Re: Casitas Del Camino at 120 60th ST NW
Erosion and Sediment Control Plan
Engineer's Stamp Date – 10/27/25 – K11E005A (SWQ-2025-00061)

Based on the information in your submittal received on 11/25/25, the ESC Plan can't be approved until the following comments are addressed.

EROSION AND SEDIMENT CONTROL PLAN

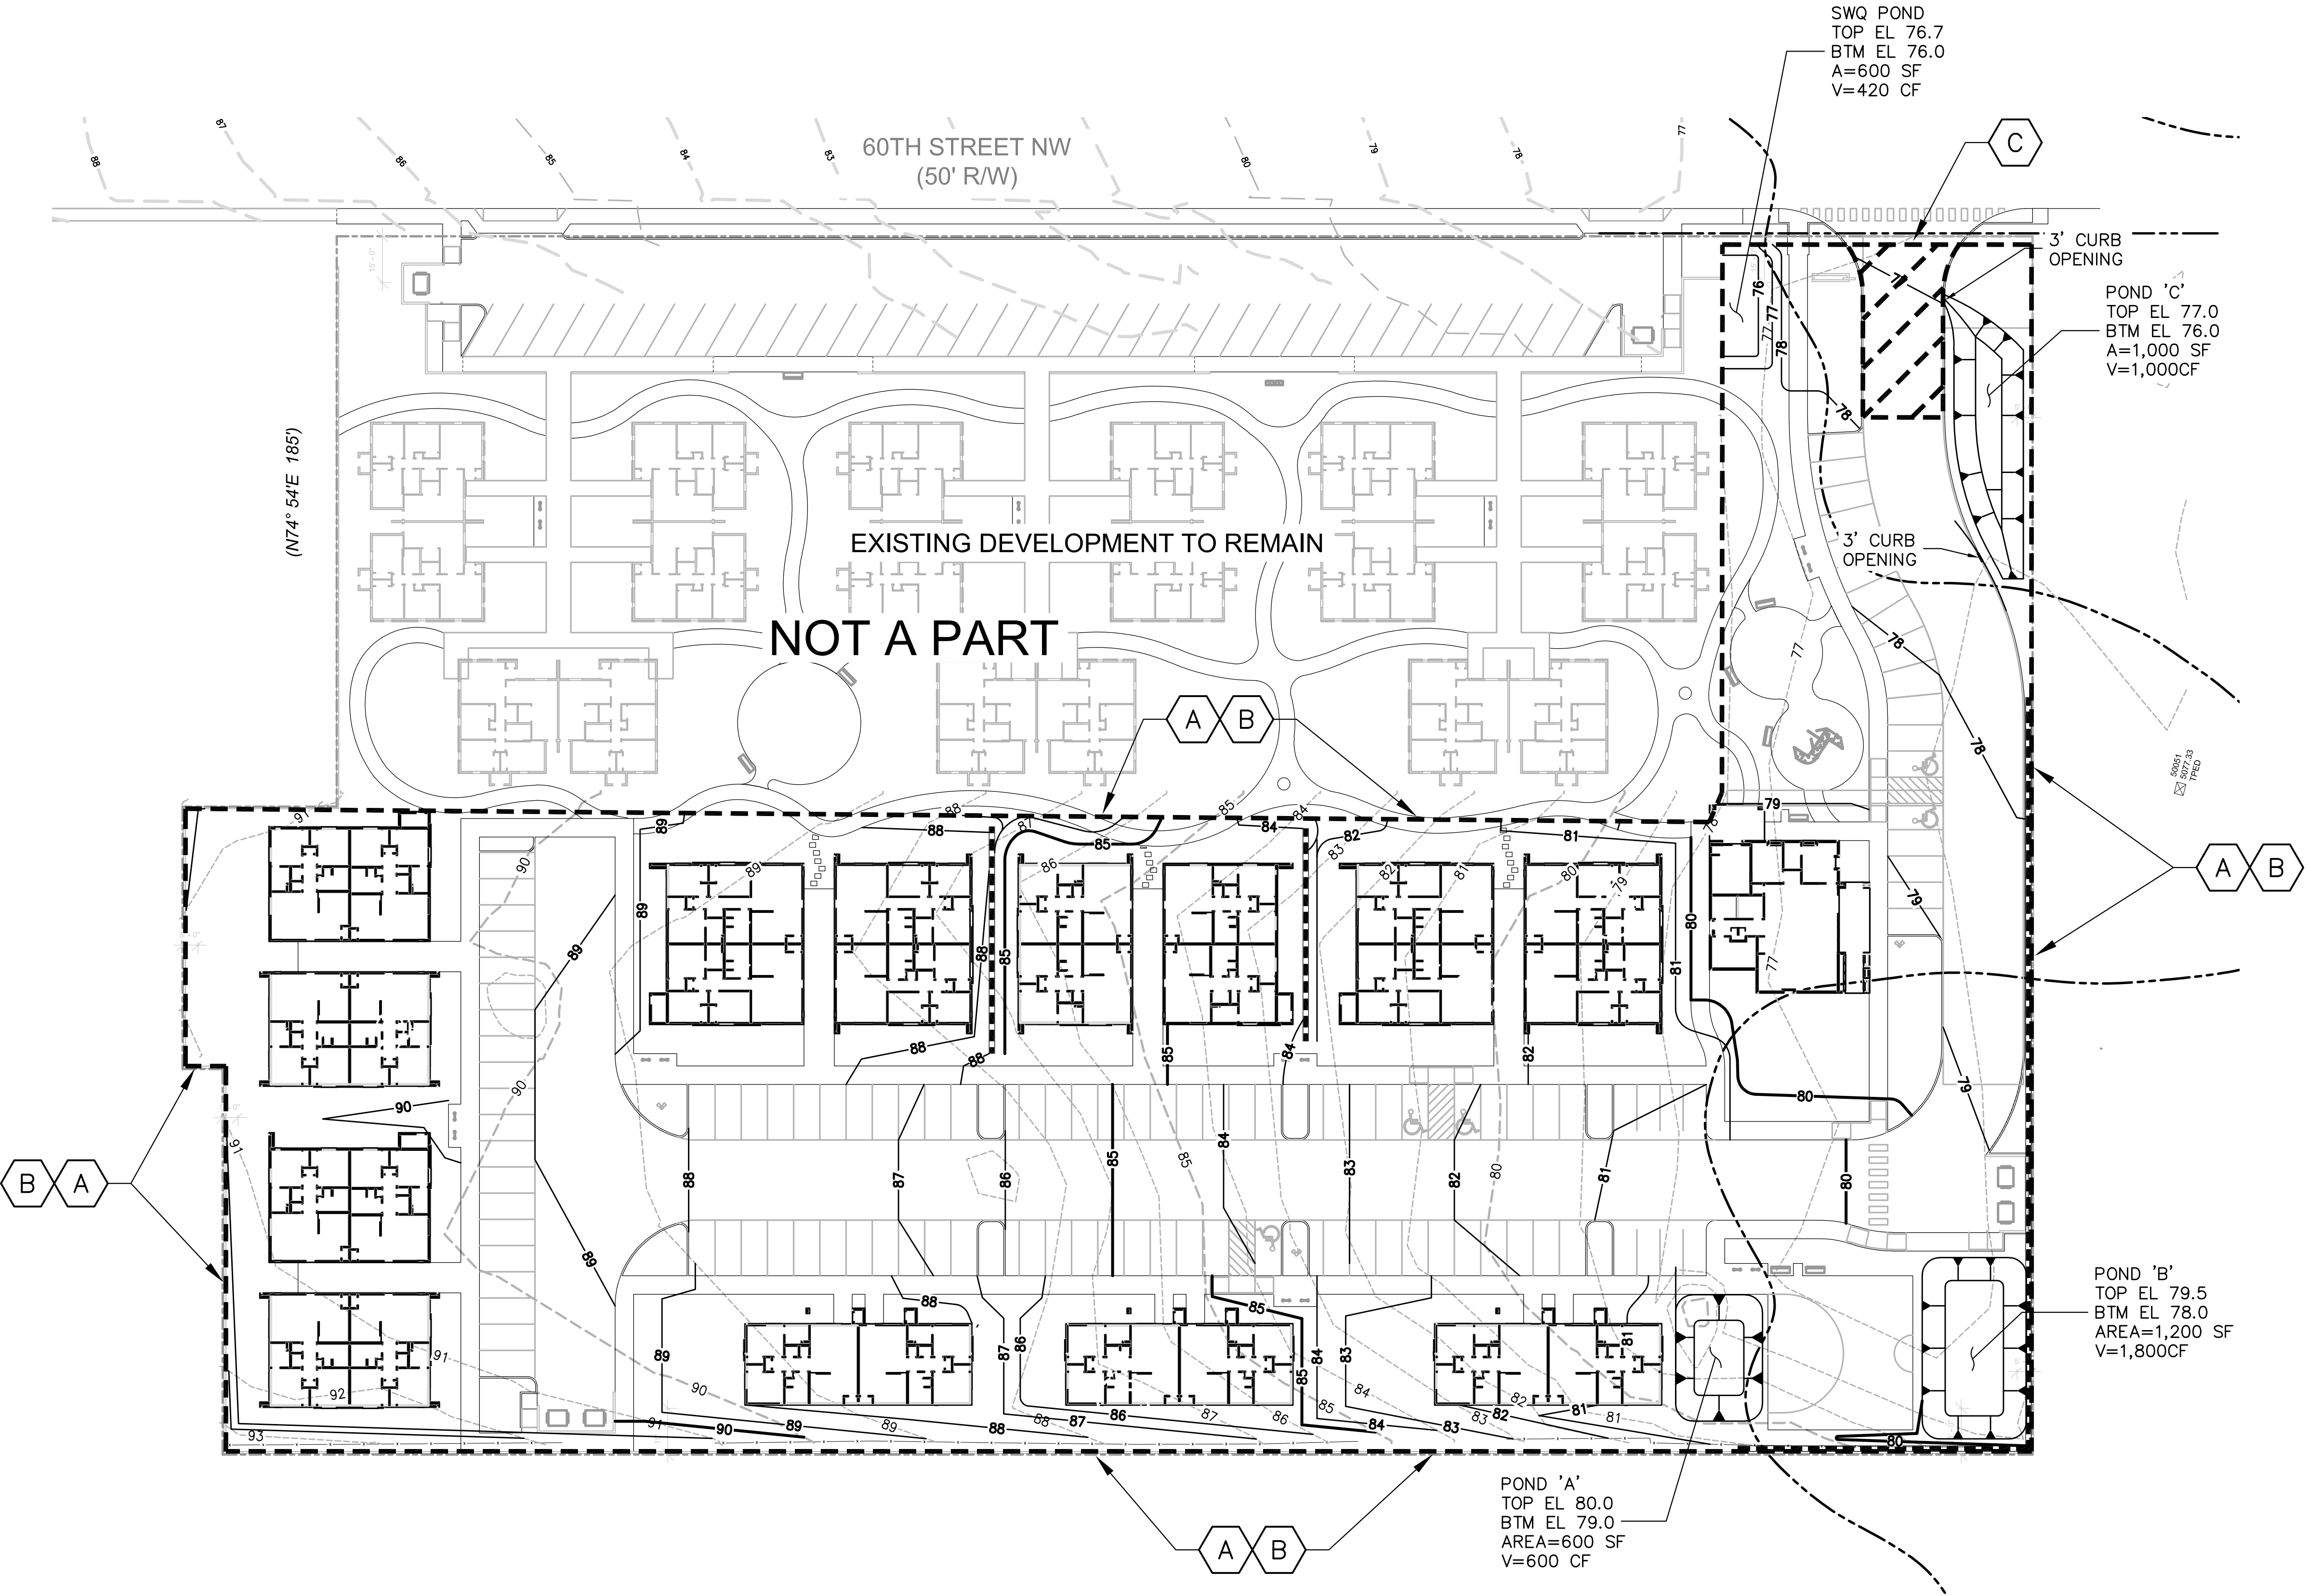
2. The G&D Plan approved by the Hydrology Section shows more areas of land-disturbing activities than are identified on your ESC Plan. The two plans must agree.

3. Describe the nature and extent of construction activities per CGP 7.2.3.a. Describe the nature of construction activities on the ESC Plan, beginning with the initial establishment of the BMPs, posting of permit coverage, and any demolition covered by the permit. Include a description and project schedule of the construction activities in each portion of the site per CGP 7.2.3.f including earthwork, utilities, vertical construction, paving, final stabilization, removal of BMPs, Certificates of Occupancy, and filing NOT. Specify the Conditions for terminating CGP coverage per CGP 8.2 in the sequence of construction, including the timing of the conversion of the temporary sediment traps into the post-construction SWQ ponds. Also note the property's size and the total area of land-disturbing activities.

5. I can't tell the difference between existing and proposed structures. The ESC plan must clearly differentiate between existing structures to remain and new structures per CGP 7.4.2.b.vi. The site plan may be included in the ESC Plan submittal in ABQ-PLAN and in the SWPPP, on separate sheets from the ESC Plan, to clearly identify all structures. However, the limits of disturbance must be shown on the ESC Plan for all areas of land-disturbing activities per CGP 7.2.4.b.i.

7. The stormwater controls are insufficient, and the BMP details are substandard. Silt fences are not suitable for the large drainage areas and concentrated flows on this site. You must *"design and install all stormwater controls in accordance with good engineering practices, including applicable design specifications"* per CGP 2.1.3. The NMED requirements in CGP 9.6.1.c.i state: *"The SWPPP must also describe design specifications, construction specifications, maintenance schedules (including a long-term maintenance plan), criteria for inspections, and expected performance and longevity of these BMPs. For sites greater than 5 acres in size "BMP selection must be made based on the use of appropriate soil loss prediction models or equivalent generally accepted soil loss prediction tools,"* and part 9.6.1.c.iii states: *"All SWPPPs must be prepared in accordance with good engineering practices by qualified (e.g., CPESC certified, engineers with appropriate training) erosion control specialists familiar with the use of soil loss prediction models and design of erosion and sediment control systems based on these models."* Documentation is required on the ESC Plan. Please replace the BMP details in the ESC Plan with standard details that include design specifications, construction specifications, maintenance schedules, and inspection criteria. Also, provide design calculations and construction specifications specific to this site for Sediment Traps that will retain the necessary volume specified in CGP 2.2.12 from the entire watershed draining to them, where stormwater from this site exceeds the silt fence design specifications. The attached draft BMP details may be helpful.

9. Soil information – add a table with name type, particle sizes, and Erodibility factor per CGP 2.1.1. Include soil loss calculations on the ESC Plan per CGP 9.6.1.c.i. if applicable.
